COMMUNITY DEVELOPMENT DEPARTMENT  
80 Columbia Avenue ♦ Marysville, WA 98270  
(360) 363-8100 ♦ (360) 651-5099 FAX

November 1, 2022

Re: James G. Murphy Auctioneers – *Technical Review 1*  
PA22037

SHEET P1 of P1  
24x36  
PreApp 22-020 G22

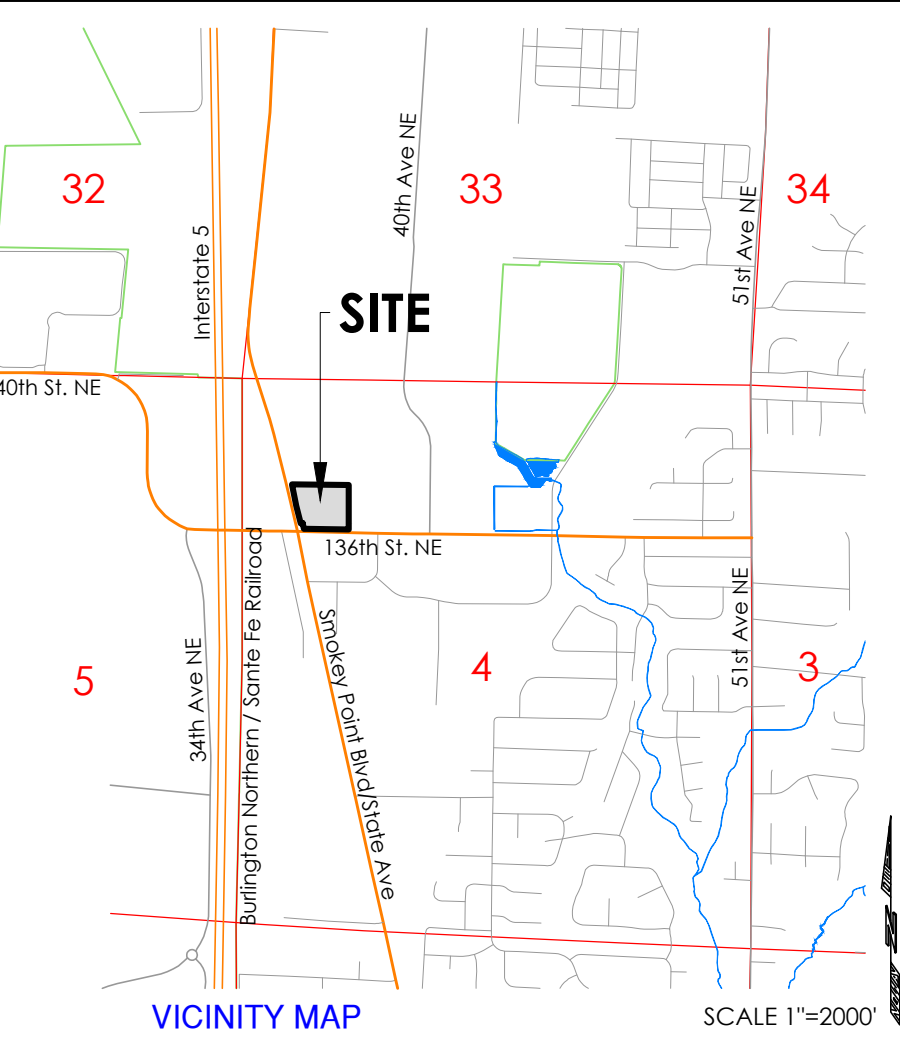
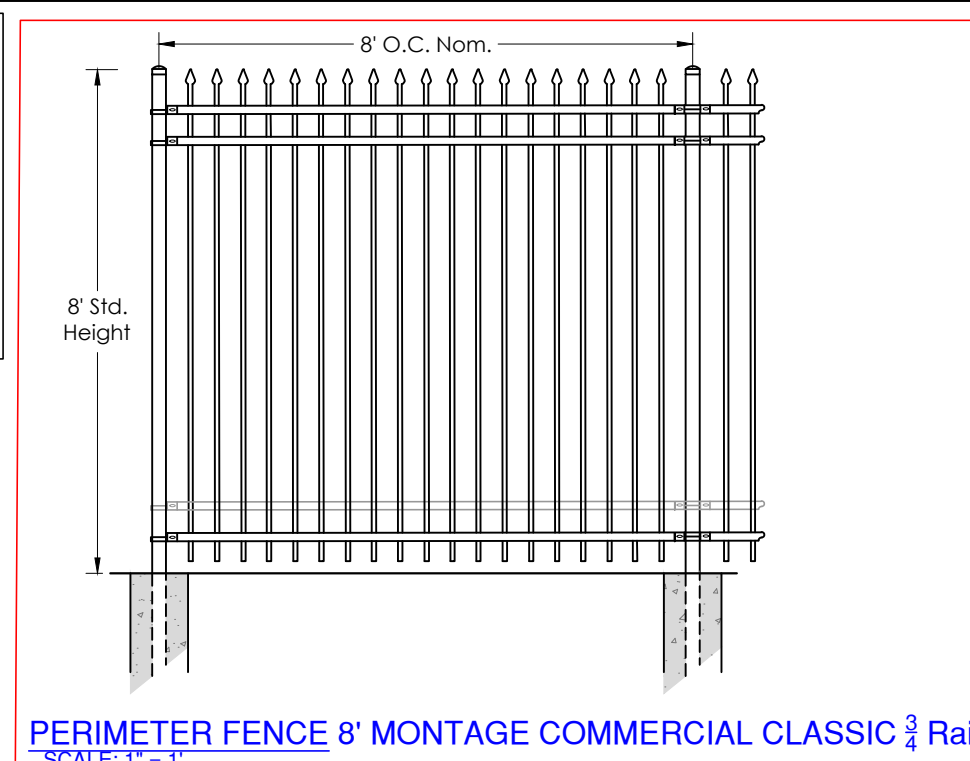
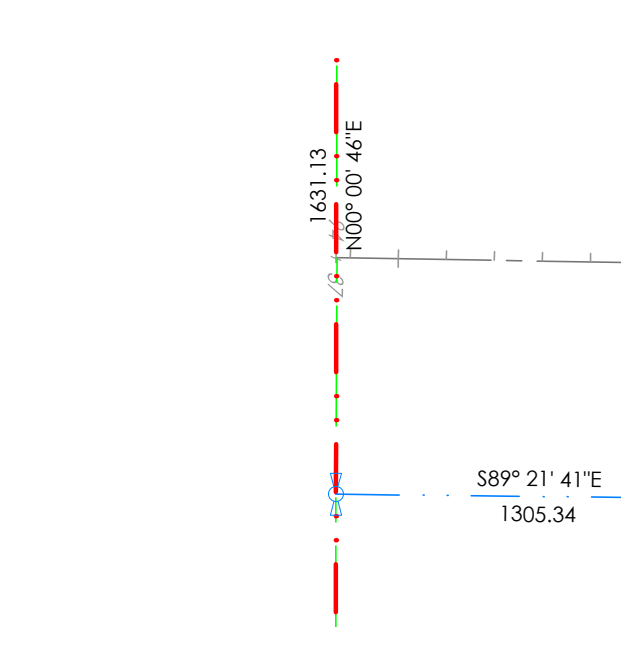
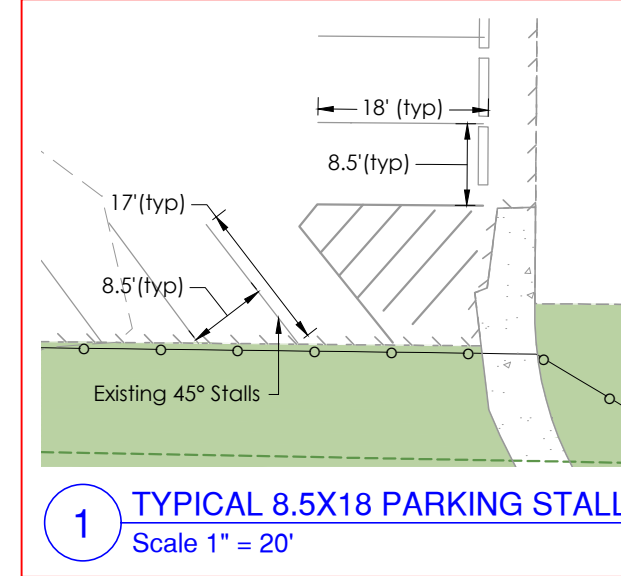
4. Sheet P1 shall be amended, as follows:
  - a. Include File No. PA22037 on all future plan submittals.
  - b. Depict all encumbrances outlined in the Title Report prepared by Chicago Title Insurance Co., dated September 28, 2022, including reference to the applicable Auditor's File Number (AFN). If the encumbrances cannot be depicted then they shall be referenced.

- c. Pursuant to MMC 22C.020.320, storage space shall be apportioned and located in collection points, and designed, as follows:
    - . Commercial:
      - 3 SF per every 1,000 SF of manufacturing GFA.

- Weather protection of recyclables shall be ensured by using weather-proof containers or by providing a roof over the storage area.
- d. In addition to the collection for recyclables outlined above, all developments shall provide a designated spot for service elements (refuse and disposal). Such elements shall meet the following requirements:

- Preferably, service enclosures are integrated into the building itself.
- e. Provide 5' minimum width landscape islands at the end of parking rows and every 10 stalls. Protective curbs are required around the perimeter of all interior landscaped areas.

- f. Pursuant to MMC 22C.130.050(3)(a)(i) in order to control dust and mud, all vehicle areas must be surfaced with a minimum all-weather surface. Gravel surfacing is not considered an all-weather surface.

- g. Bicycle parking shall be provided at a rate of 5% of the number of required off-street auto parking spaces.
- h. The proposed off-street parking stalls do not comply with the dimensional requirements outlined in MMC 22C.130.050 Table 2, particularly the stall depth for both the perpendicular and angled stalls.

- i. The proposed ADA stall is required to be a van accessible stall with an 8' load and unload area. The parking stall shall be amended accordingly.
- j. Provide a minimum 5' wide raised pedestrian pathway along the frontage of the building.
